Job No: IAC-333

Reference: Eastern Offices Accessibility Review – Access Report
Development Application

ACCESS REPORT DEVELOPMENT APPLICATION

Project: Sydney Opera House
Eastern Offices
Document Type: Access Report – Development Application
Report Number: IAC-333

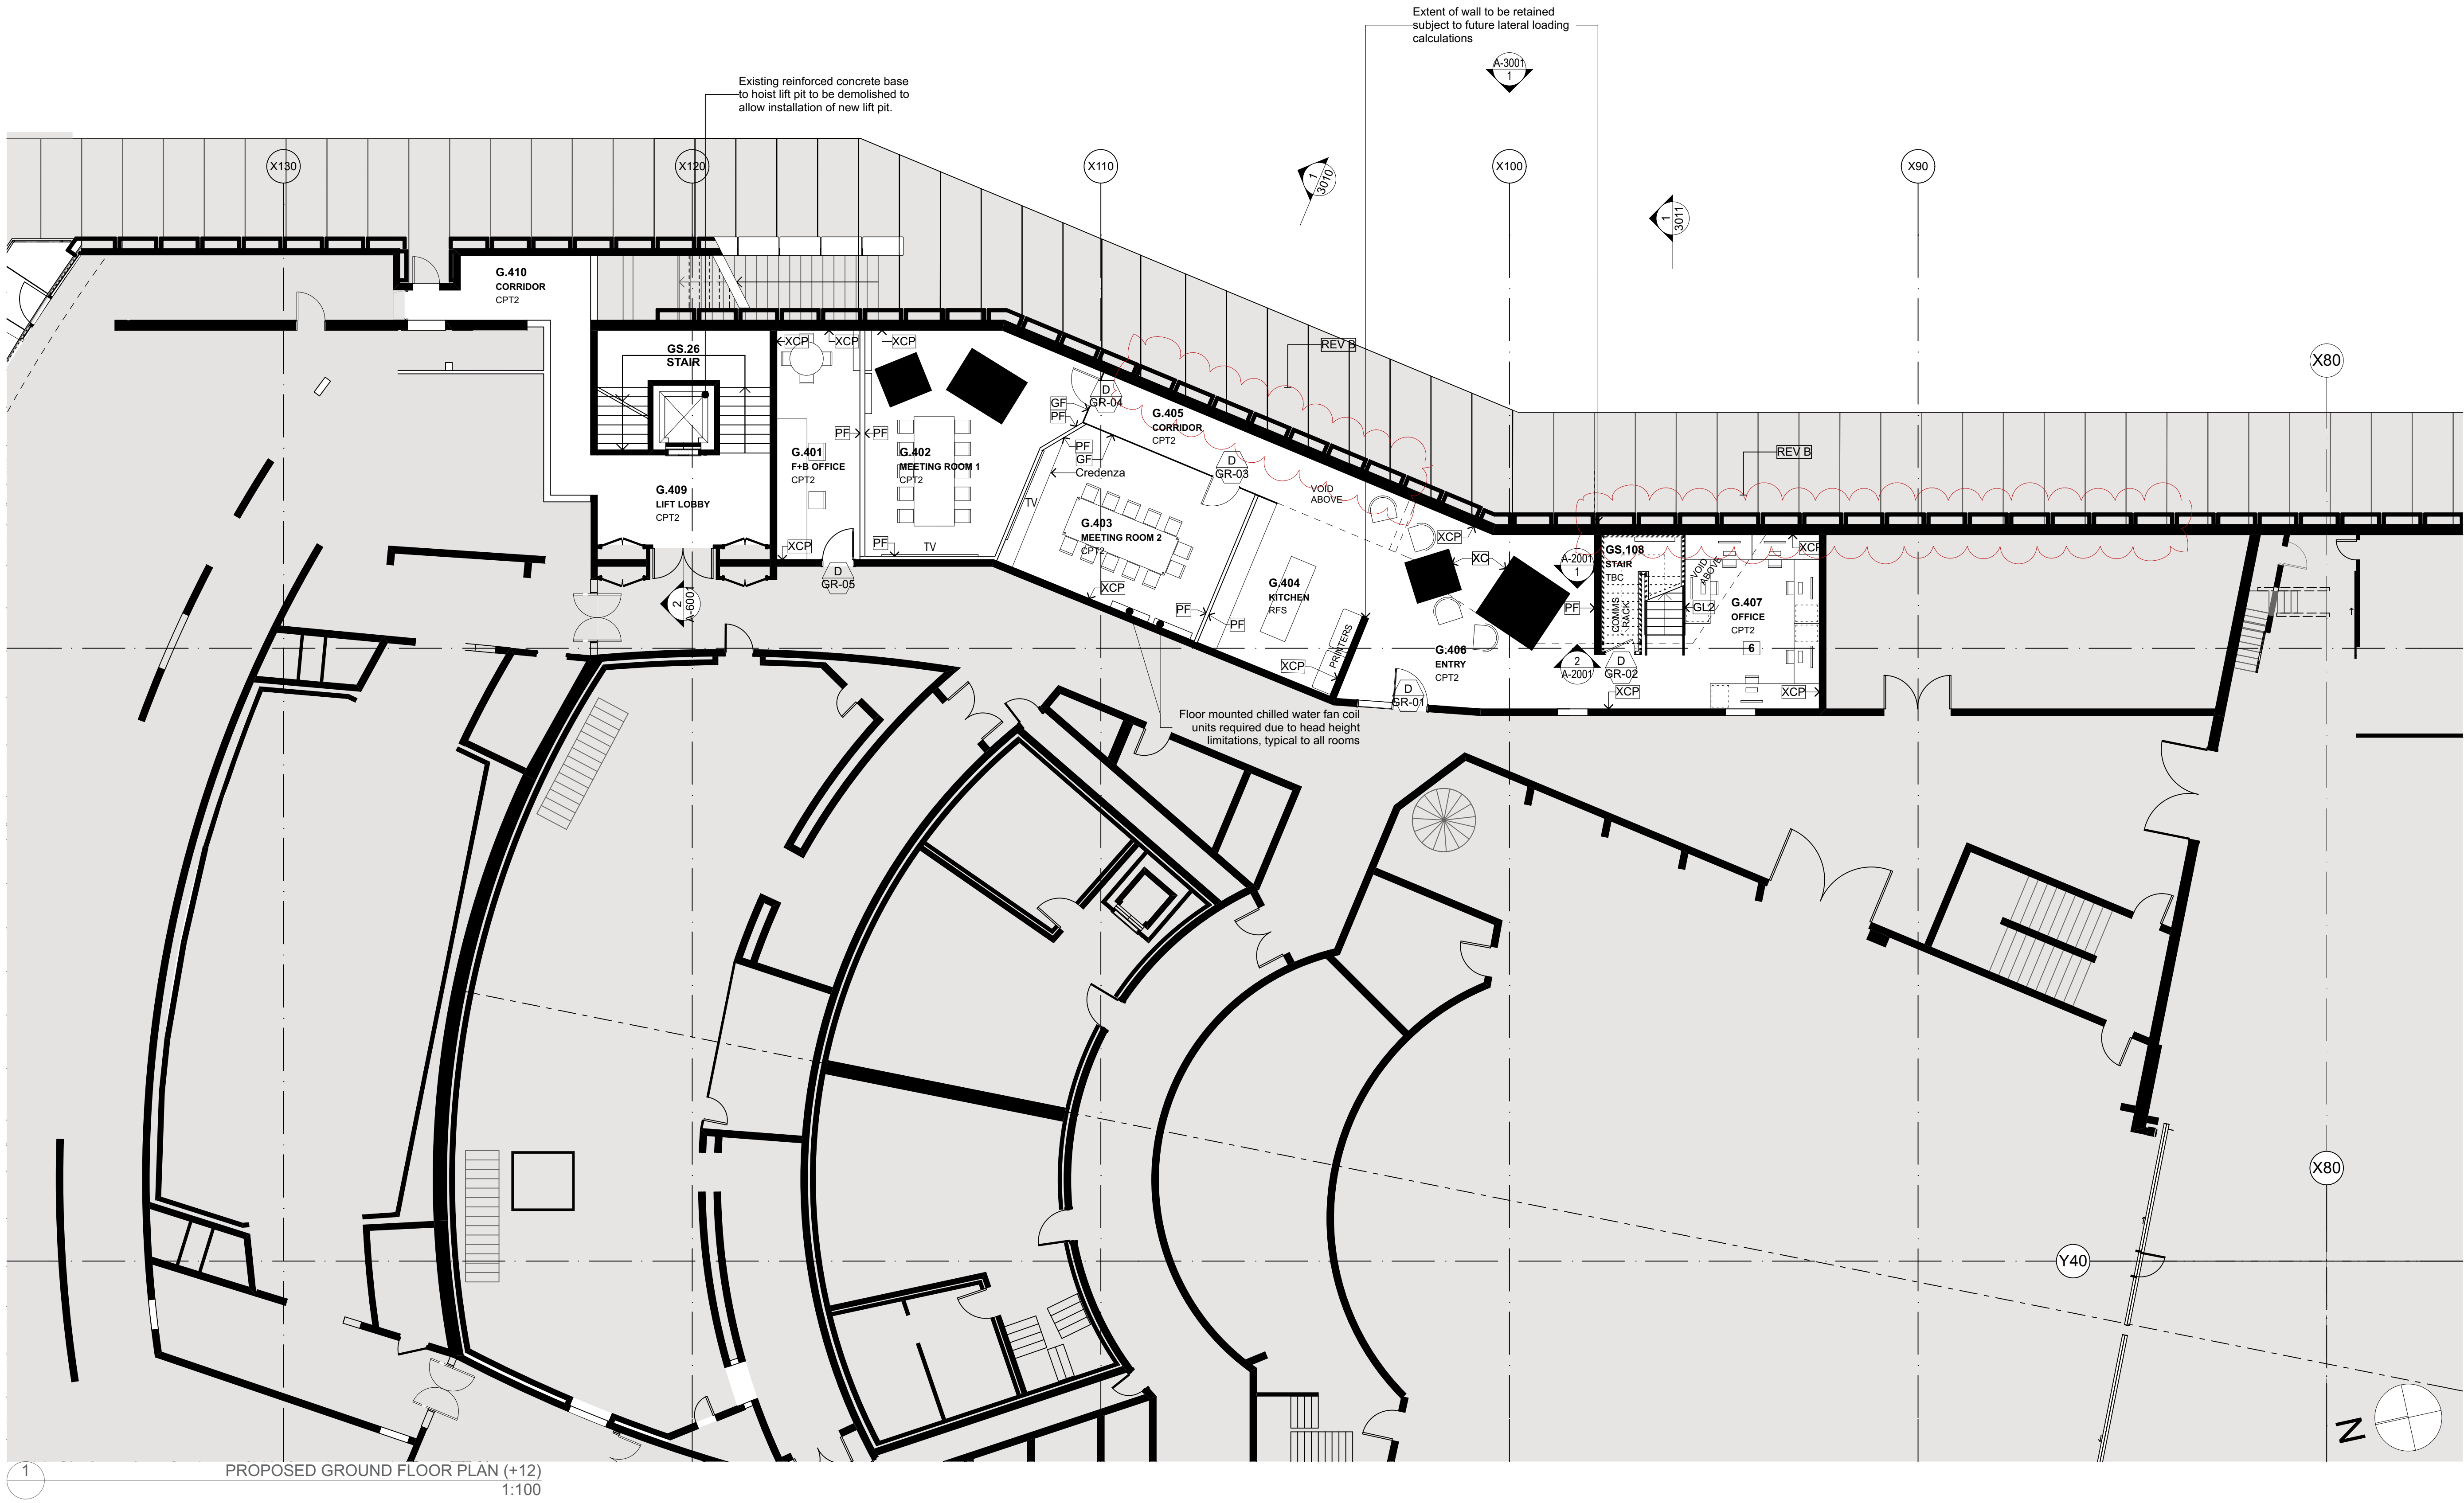
The F+B Office (G.401) may require review.

It will be essential to demonstrate that it is possible for a wheelchair user to make a 180deg turn within this office. The Standard nominates that a zone of 1540 x 2070 is required to undertake this turn.

The plans nominate that the floor finish within the office area is to be carpet.

The selection of the carpet will need to demonstrate compliance with Clause 7.1 – Fixed or recessed floor coverings of AS1428.1:2009.

PROPOSED MEZZANINE PLAN (+21)
1:100

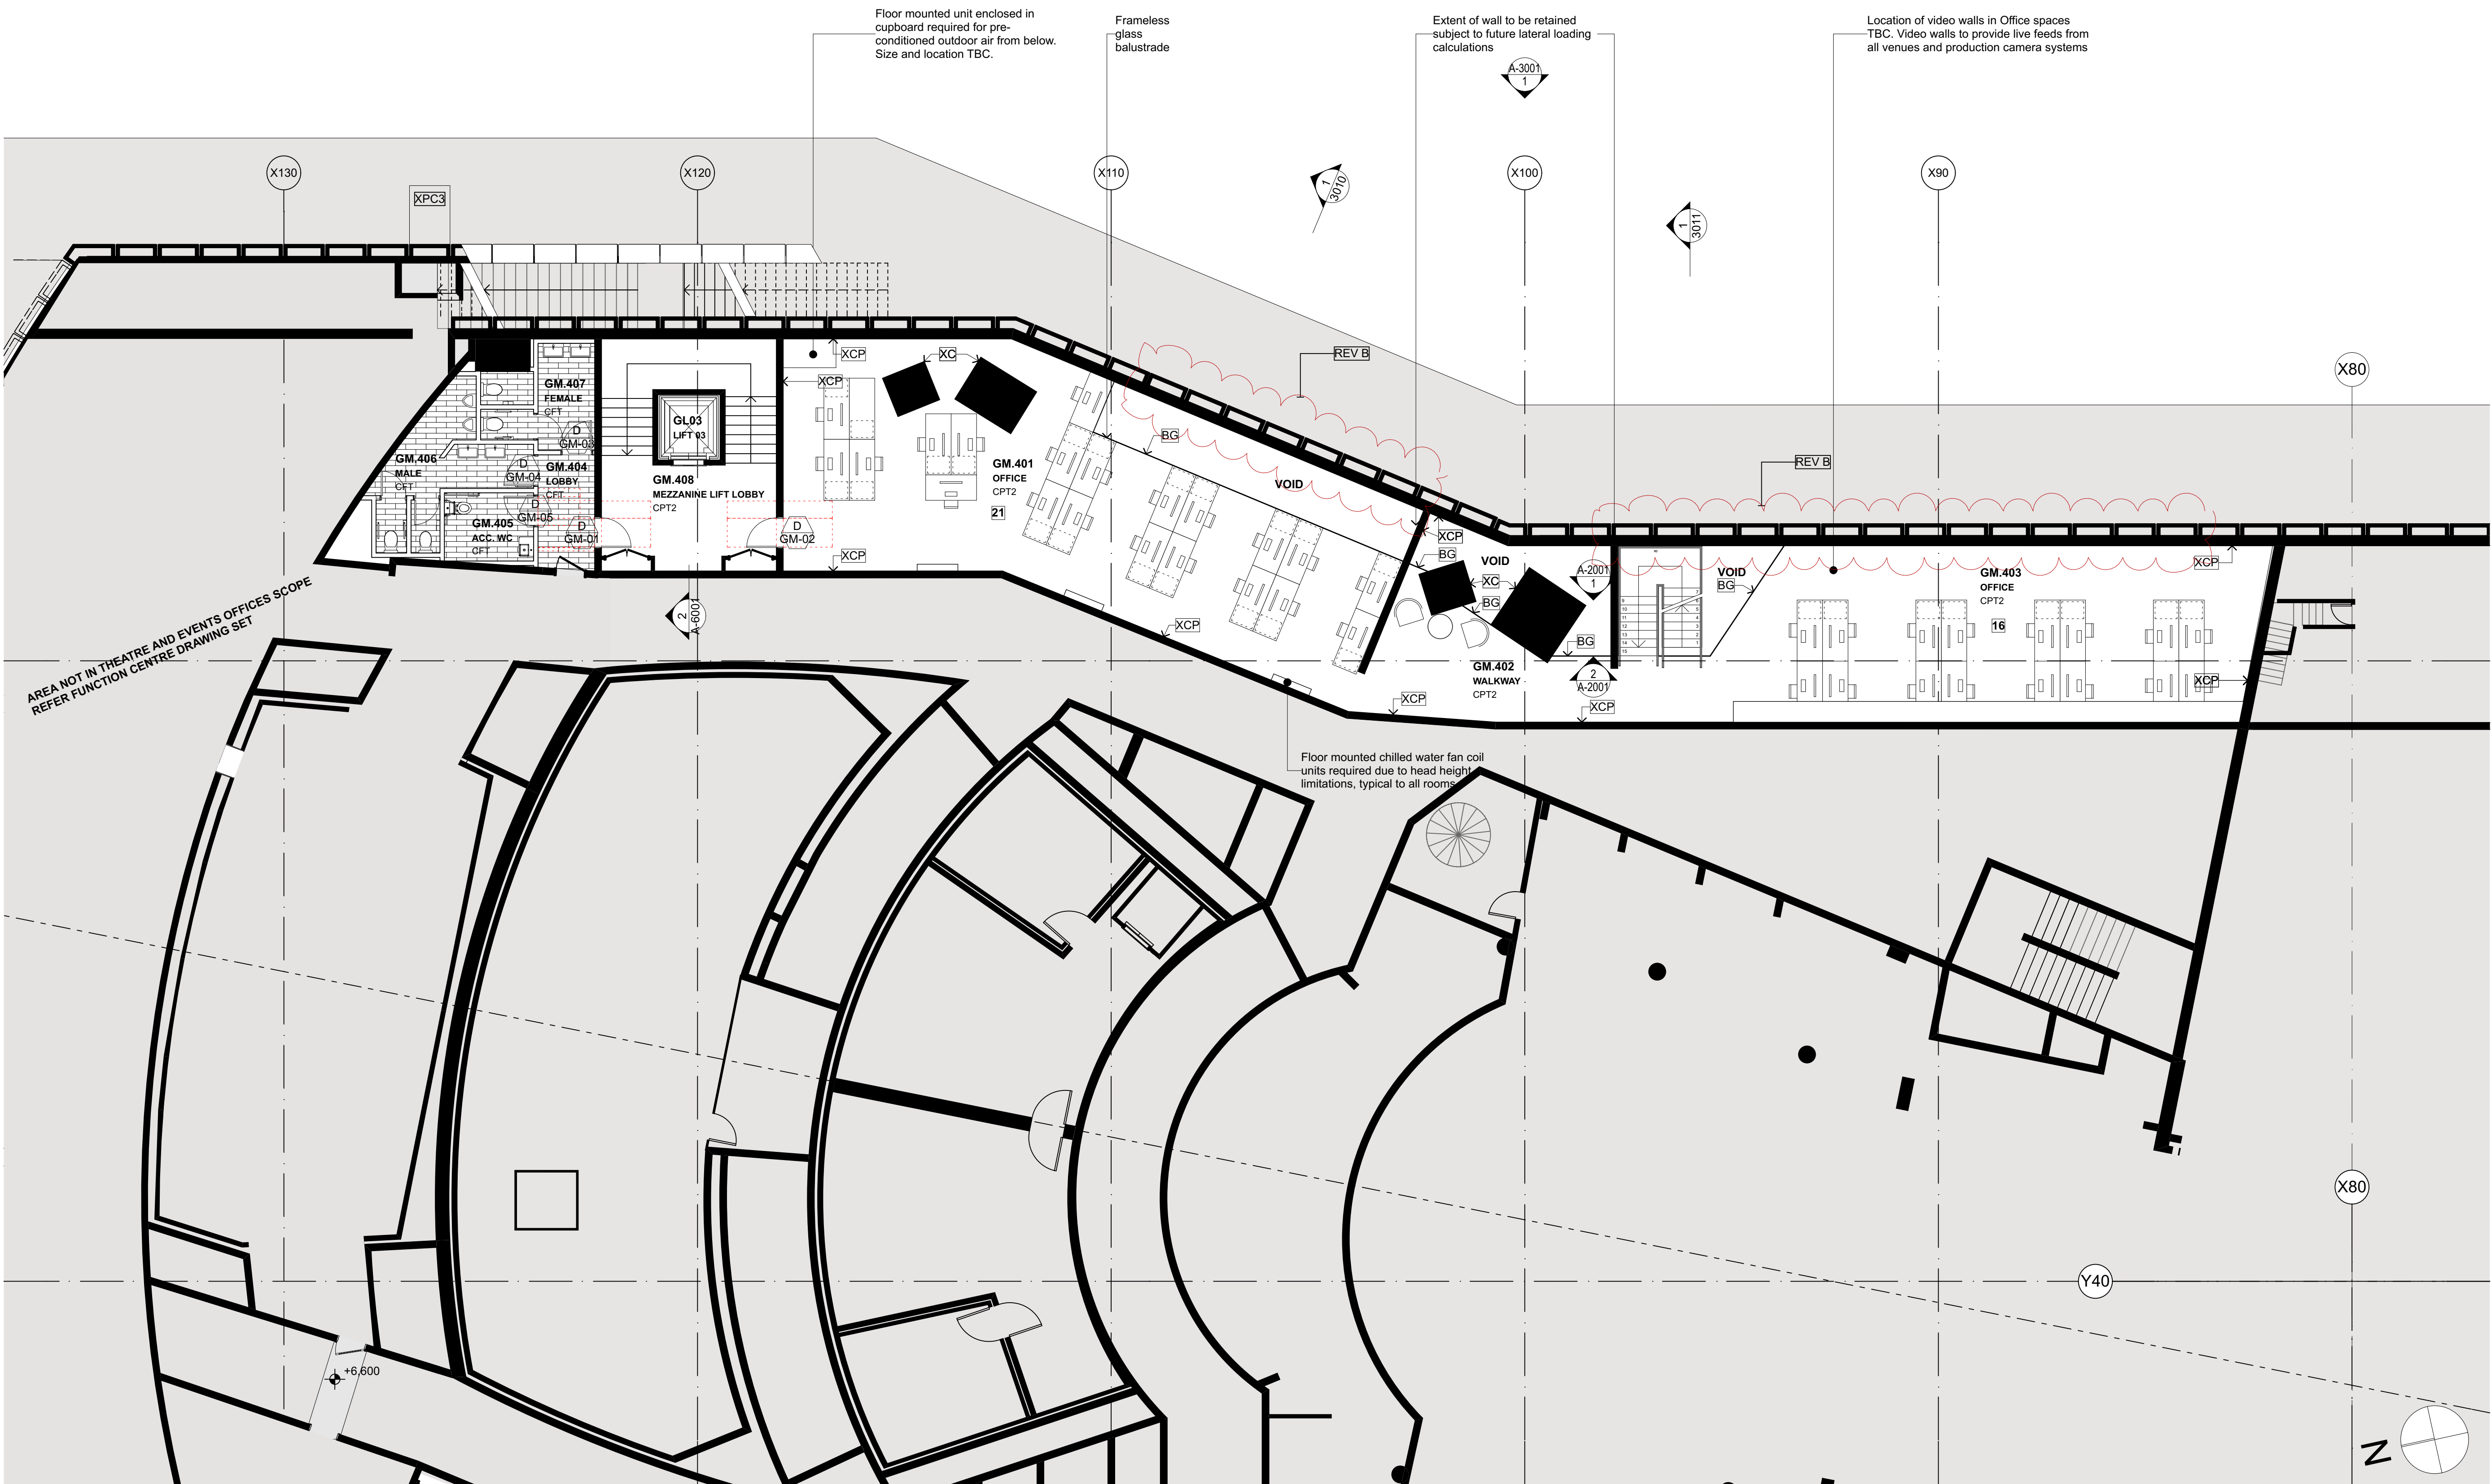
The detailing of this stair will need to be upgraded from a fire Isolated stair as this stair will become a circulation stair connecting these two levels.

The following will need to be provided to the flights connecting the two office levels:

- Handrails installed to both sides of the stair flights
- Provision of compliant handrail extensions
- Non slip goings
- Installation of non-slip nosing to each going
- Installation of warning TGSIs at landings (TGSIs not required at mid-landings)
- Compliant lighting levels

A new stair is proposed to be installed within the Theatre and Events Office.

The position of the stair will need to be adjusted so that the handrail extensions do not encroach on the path of travel.

The detailing of the interconnecting stair will need to demonstrate compliance with Clause 11 and 12 of AS1428.1:2009. Specific attention is directed to:

- Handrails design
- Compliant handrail extensions and handrail terminations
- Non slip going
- Installation of non-slip nosing to each going
- Installation of warning TGSIs at landings (TGSIs not required at mid-landings)
- Compliant lighting levels
- Opaque risers

The plans indicate WC facilities associated with the Theatre and Events offices.

The plans propose ambulant facilities associated with individual male and female WC amenities. The setout of the Ambulant WC will need to satisfy the provisions of Clause 16 of AS1428.1:2009. Braille Tactile signage will need to be installed to the ambulant WC cubicle doors. The detailing and positioning of the Braille Tactile signage will need to satisfy NCC Clause D3.6 and NCC Specification D3.6.

The circulation at the doorway to the male ambulant WC will need to demonstrate compliance with the provisions of Clause 16 of AS1428.1:2009.

The sizing of the GM.404 Amenities Lobby will need to facilitate a 1540 x 2070mm zone to enable 180deg turns for wheelchair users.
